Longfield Solar Farm Draft position statement on Landscape and Visual Impact

Prepared for: Essex County Council,
Chelmsford City Council, Braintree District
Council

14th July 2022

10-12 A

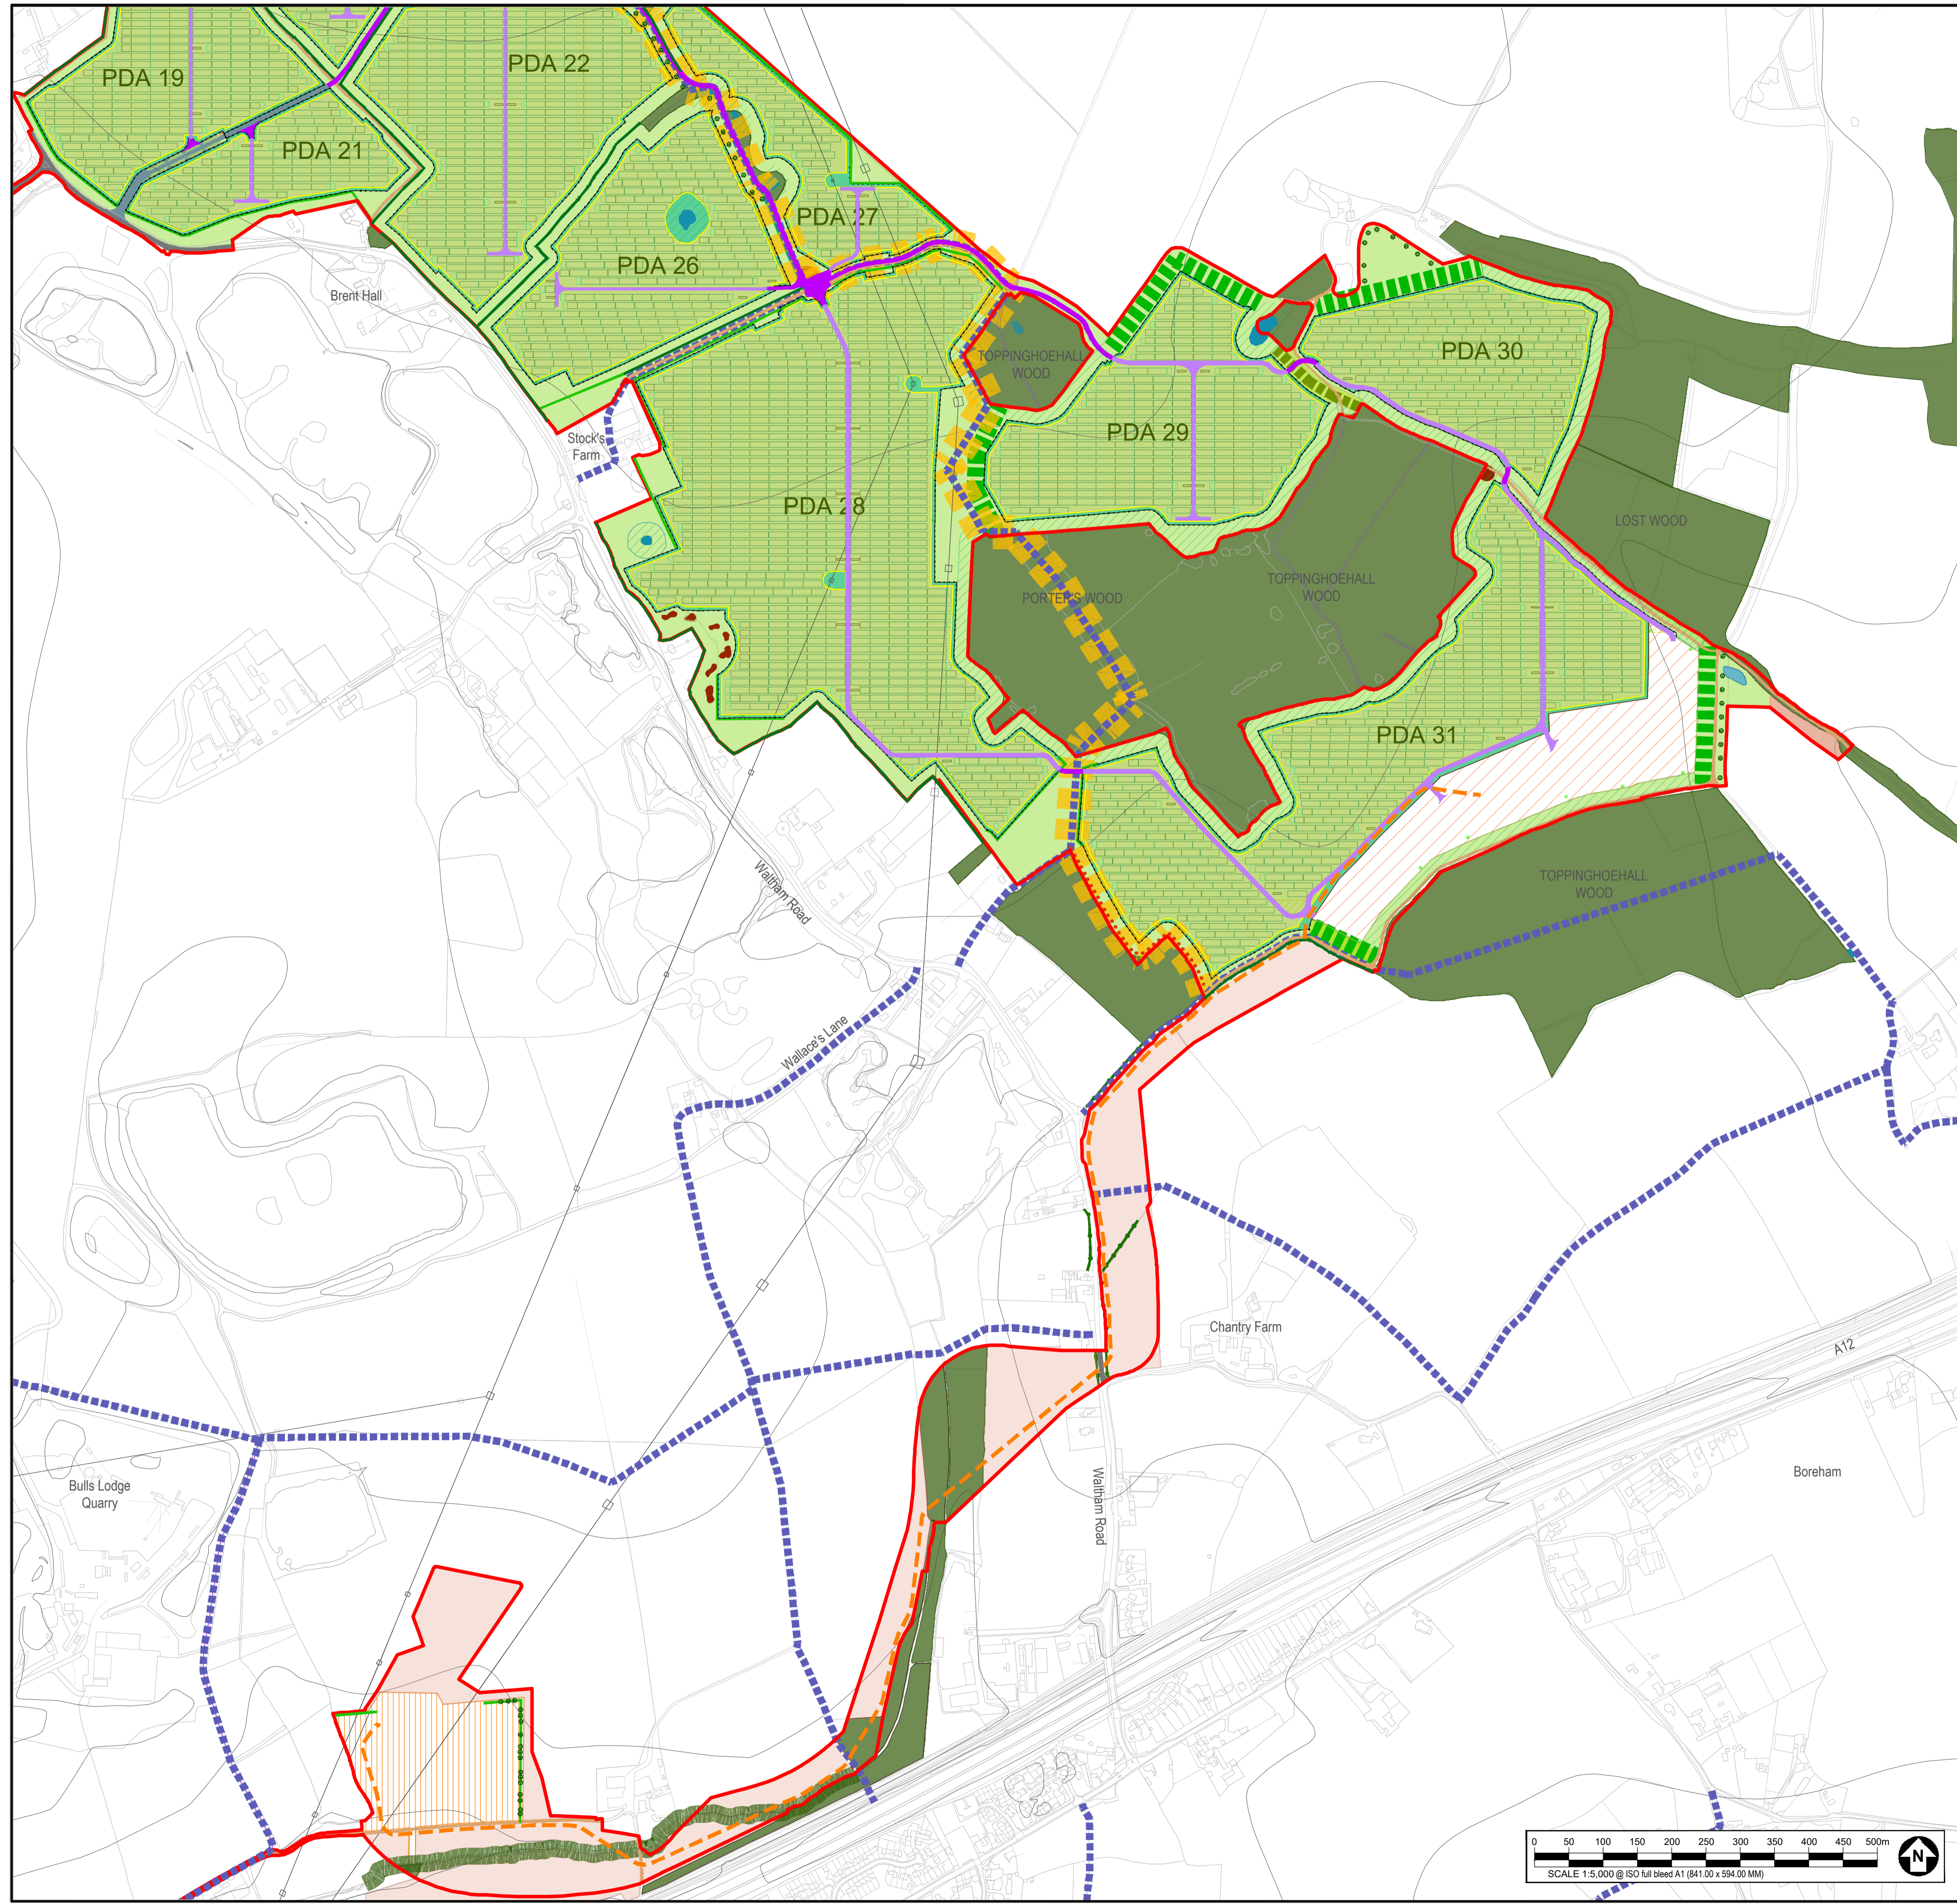
The Landscape masterplan and discussions had focussed on enhancement to hedges alongside the protected lanes and this is illustrated on the Landscape Masterplan. The Vegetation Removal Plan in the ES appears to show removal of vegetation along part of Noakes Farm Lane.

Along part of Noakes Farm Lane vegetation removal is be proposed to each side of the carriageway. This part of the Lane is designated as a Protected Lane in BDC's emerging Local Plan under policy LPP 46 and, as such, the policy is clear that any proposals that would have a materially adverse impact on the physical appearance of these protected lanes will not be permitted.

Where the Lane turns to run east-west the current proposal is to remove a length of hedgerow for approximately 93m. The hedgerow is not continuous at this point so approximately 42m of hedge planting would be removed. We understand that the trees would be retained and a replacement hedgerow planted following construction, nevertheless, this would adversely impact the physical appearance of the protected lane.

The hedgerow has not yet been surveyed in detail, although we understand that a detailed survey of the hedge and trees is to be undertaken. There may be alternatives to hedgerow removal which

should be considered. The visibility splay lengths are generated by traffic speeds so a lower speed limit during construction could reduce the requirement. Traffic management of vehicles crossing the Lane could also avoid the need to remove the hedge. Management of the hedgerow by facing up or cutting back to improve visibility could also be explored.

As the plans stand at present the proposals are contrary to the protected lanes policy.
